Case Reference: PAX91.323780

Submission by: Anthony and Bernadette Daly

**Subject: Objection to Proposed Wind Turbine Development by Ballinlee Green Energy Co Limerick**

Figure 15-3: Wind Turbine and Dwelling Locations

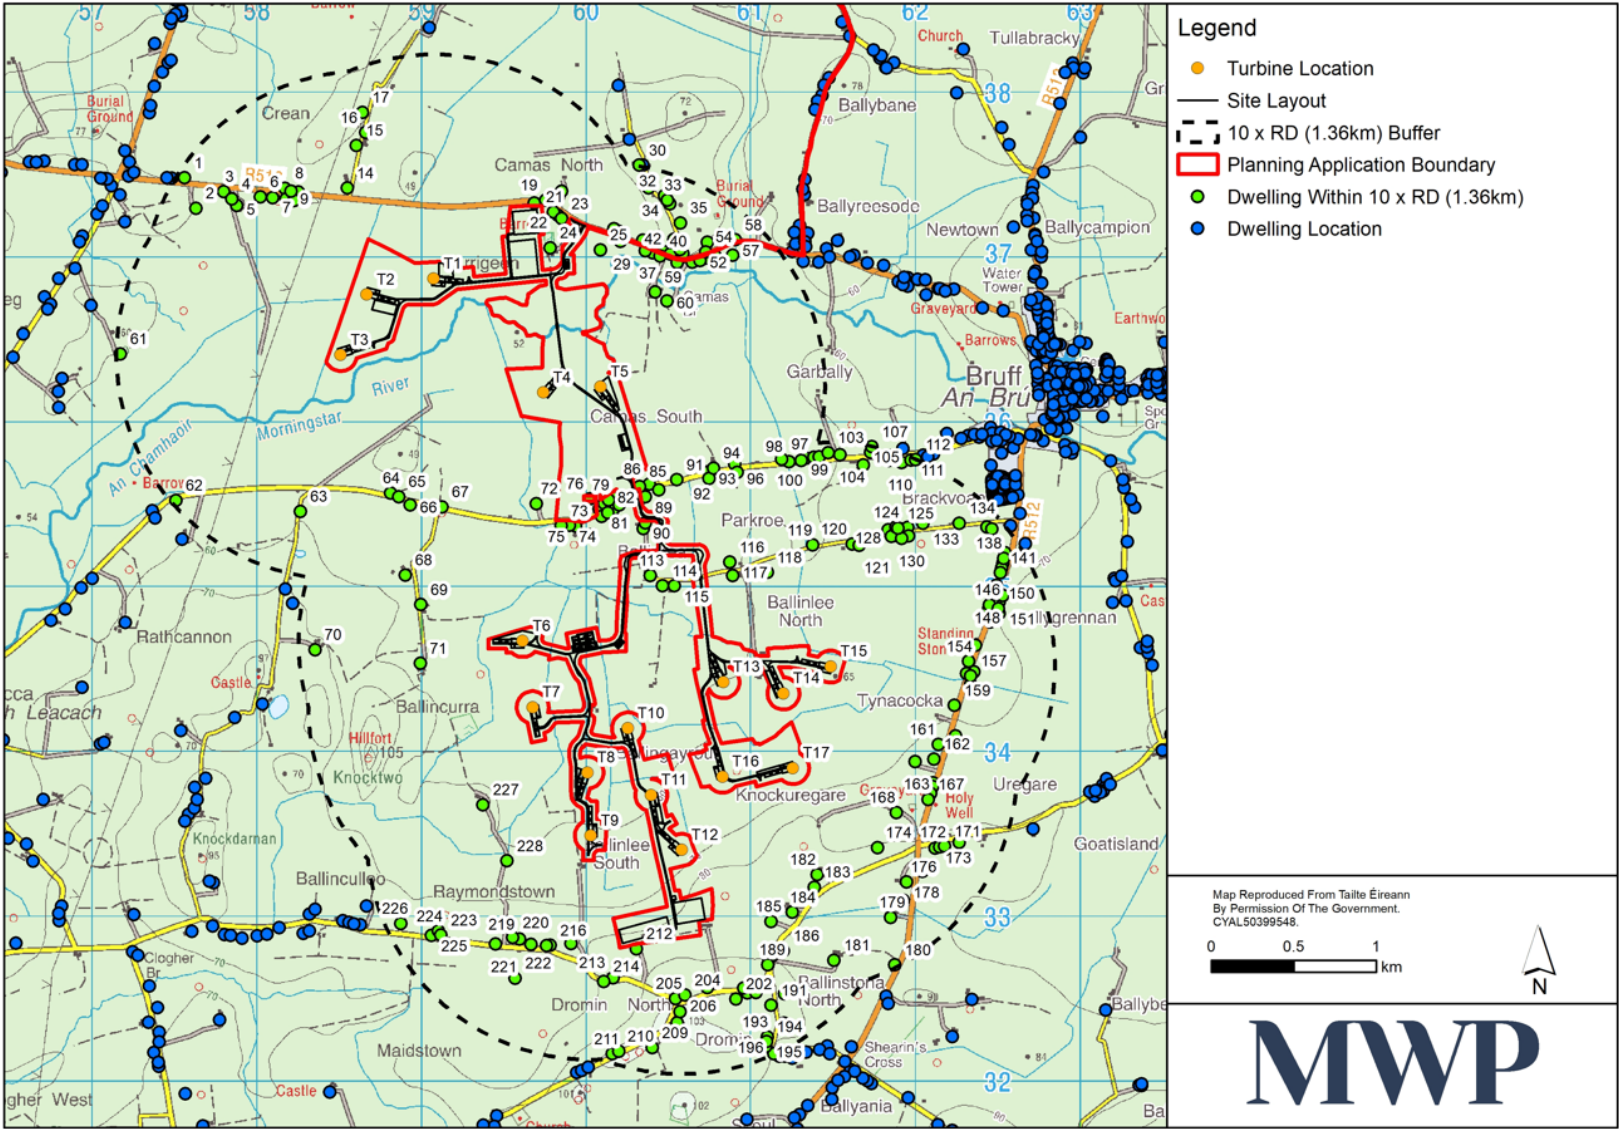
- **Shadow Flicker**: The anticipated shadow flicker from 17 turbines (12 to the south and 5 to the northwest of us) is deeply concerning. **Our home, V35RX27, has not been included in the shadow flicker assessment which was carried out by the applicant. This is a significant oversight.**
